Application No: P/9/21/HH
Site Address: 9 Kings Drive Pagham PO21 4PY
Description of works: Single storey rear extension with flat roof together with alterations to existing bay windows to the front of the property.

Thank you for your internet representation made on 8th March 2021 which has been recorded as an objection with the comments as follows:

dwg.title As Built Elevations @ A3

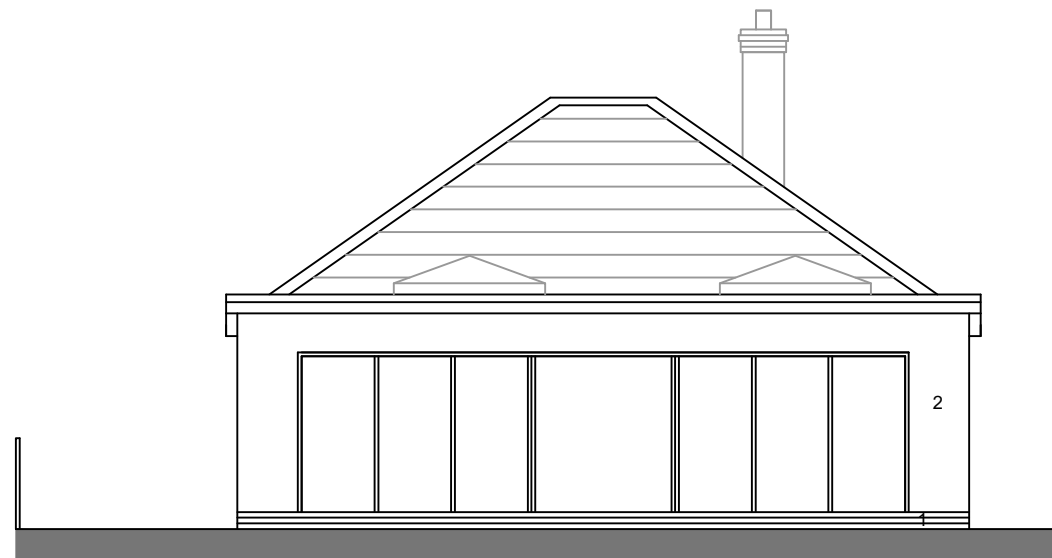
Our main objection is the height of the large extension at the rear of the property. As it is already built we assumed planning permission had been given, so was surprised to see the yellow notice now asking for the application to be granted.
